RE: Upgrade to North Sydney Public School SSD-11869481 RFI – Traffic and Transport Items

Reference is made to the response to submissions from Transport for NSW (TfNWS), North Sydney Council and NSW Department of Planning, Industry and Environment (DPIE) with respect to SSDA submissions for the Upgrade to North Sydney Public School (Reference SSD – 11869481). Our responses to the submissions are provided in the table below.

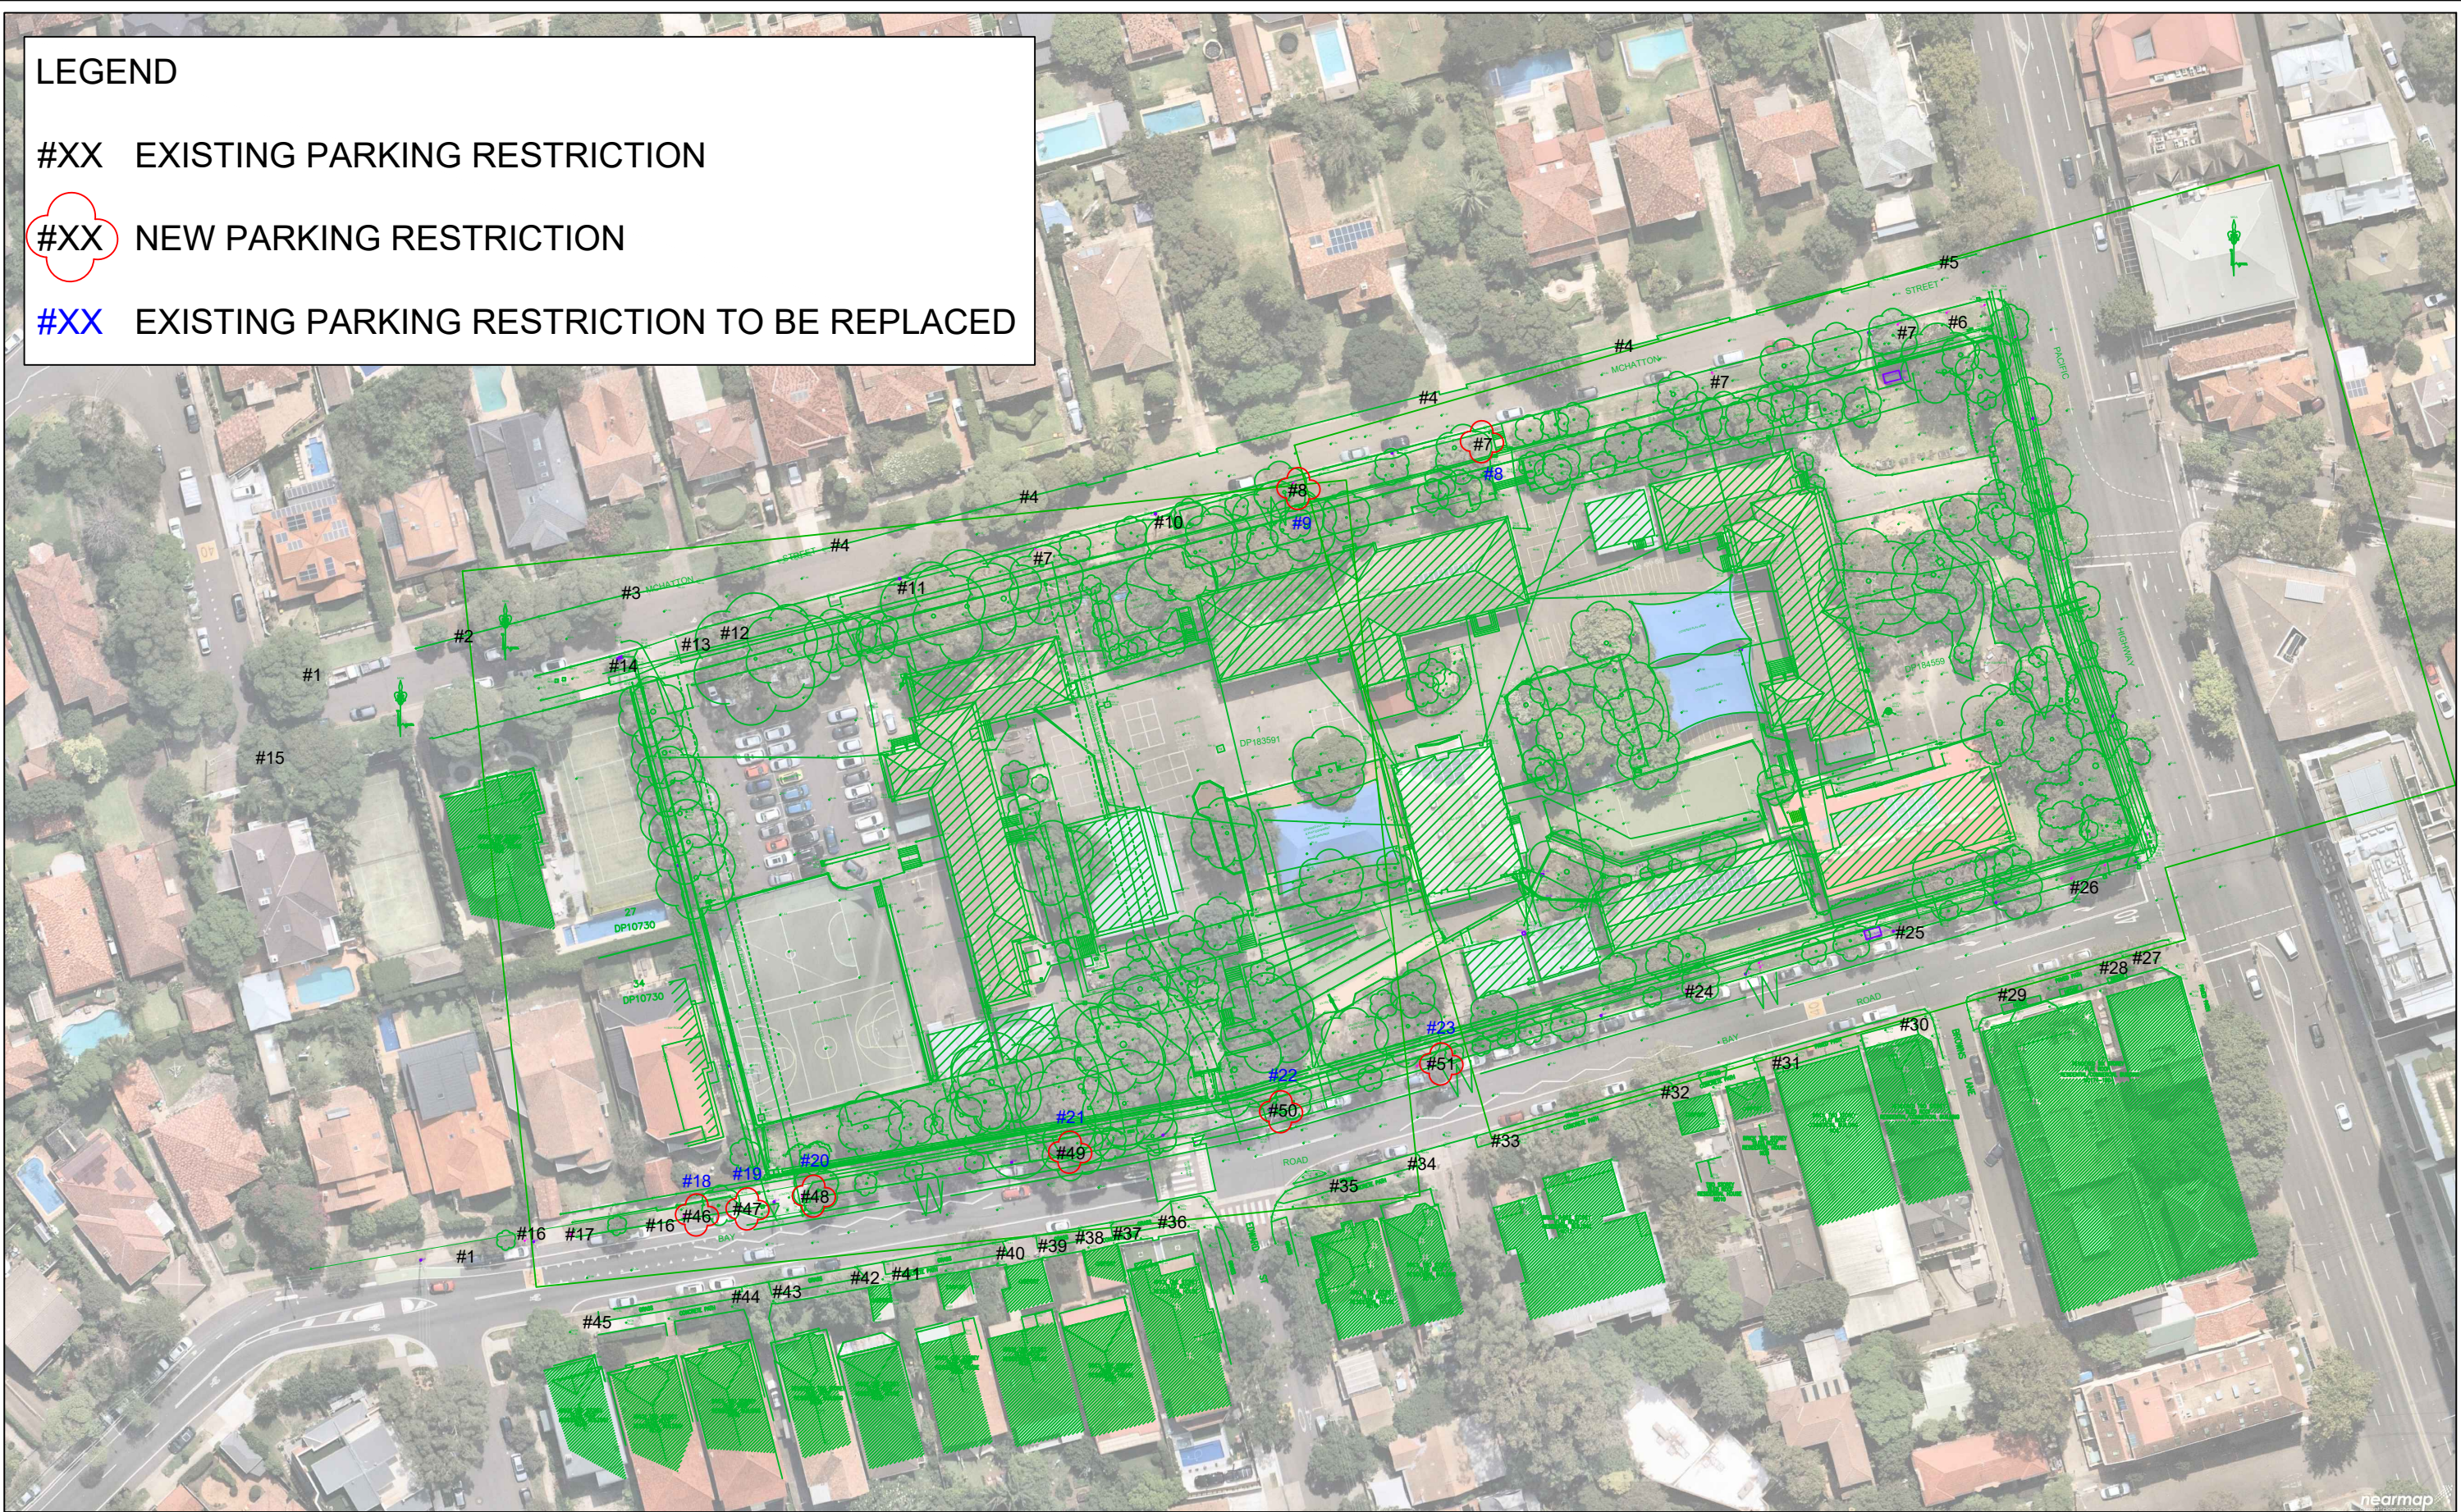
1.2	<p>Section 11.3 of the TIA states that on-site parking will not be available to construction workers on site and Section 11.8 states that there will be an average of 20 to 40 workers on-site during peak construction activities. Reliance on on-street parking is not encouraged where there are alternative options for off-street parking. No justification has been provided regarding the availability of on-site parking and no on-street parking analysis has been provided to demonstrate existing parking availability on streets for construction worker parking use. Further, the majority on-street parking surrounding the site is time restricted and the proposed temporary work zone on Bay Road would remove time restricted parking during construction periods which would likely shift on-street parking demand to surrounding streets.</p> <p>The RtS must include additional information detailing:</p> <ul style="list-style-type: none"> a) if construction worker parking can be accommodated on-site. b) measures to minimise construction worker parking demand. c) where there is likely to be overflow on-street parking required, the capacity of the surrounding proposed streets to ensure construction worker parking does not detract significantly from existing on-street parking supply. 	<p>It is expected that the SSDA will have conditions of approval that requires the submission of a detailed Construction Traffic Management Plan to Council and Transport for NSW, which will capture the construction workers parking arrangements.</p> <p>Based on the assessment undertaken, it is anticipated that:</p> <ol style="list-style-type: none"> 1) Construction worker parking can only be accommodated on-site during school holidays, weekends and outside of school operational hours. 2) The contractor will be informed of the public transport options (i.e., site's proximity to railway stations and bus services), as well as the closest commercial parking opportunities, and be advised that no on-site parking will be available. This arrangement can typically be accommodated with the establishment of a drop-off zone for contractors to temporarily drop off equipment and be afforded with storage of equipment on-site at the start and end of each shift, prior to the driver seeking a commercial car park to park their vehicle. Similar arrangements are commonly in place for construction in areas such as North Sydney and the Sydney CBD. <p>Examples of such arrangements are common and in place throughout the duration of works for 1 Denison Street (completion in early 2020), 88 Walker Street Development, Crows Nest Sydney Metro Station Development, The Landmark Development at 500 Pacific Highway, St Leonards.</p> <ol style="list-style-type: none"> 3) Based on observations undertaken during the preparation of the Transport Assessment, it is noted that all public roadway within 400 metre walking distance to the site are subject to strict parking restrictions that comprises a mix of 1-hour, 2-hour, No Parking, Mail Zone restrictions along nearby residential and commercial property frontages. The parking restrictions are typically applicable between 8:30am – 6:00pm, Monday to Friday. <p>Along the immediate frontages of the School along Bay Road and on both sides of McHatton Street, restrictions are applicable with a mix of 2-hour restrictions outside Kiss and Drop hours, and a mix of No Parking, No Stopping and 5-minute parking applicable during Kiss and Drop hours on school days. The presence of parking restrictions on weekdays, and during typical construction hours meant that the reliance of on-street parking for construction worker parking is not practicable and require frequent shifting</p>

<p>of vehicles on a typical day. Refer to the attached parking restriction plans for existing and proposed parking restrictions of the immediate vicinity of the School for details.</p> <p>The on-street parking restrictions results in regular turnover of parking within the vicinity of the School. Given the school remains operational for much of the construction phase of the project, there are no on-site or on-street parking available for use by construction workers during school days.</p> <p>On weekends and during school term breaks, parking along the Bay Road and McHatton Street frontage of the school may be available for construction worker parking. Should this be required, it is the appointed Contractor's responsibility to liaise with Council and sought necessary approvals for temporary changes to existing parking restrictions to facilitate construction worker parking.</p>
No.	TfNSW Submission	Ason Response
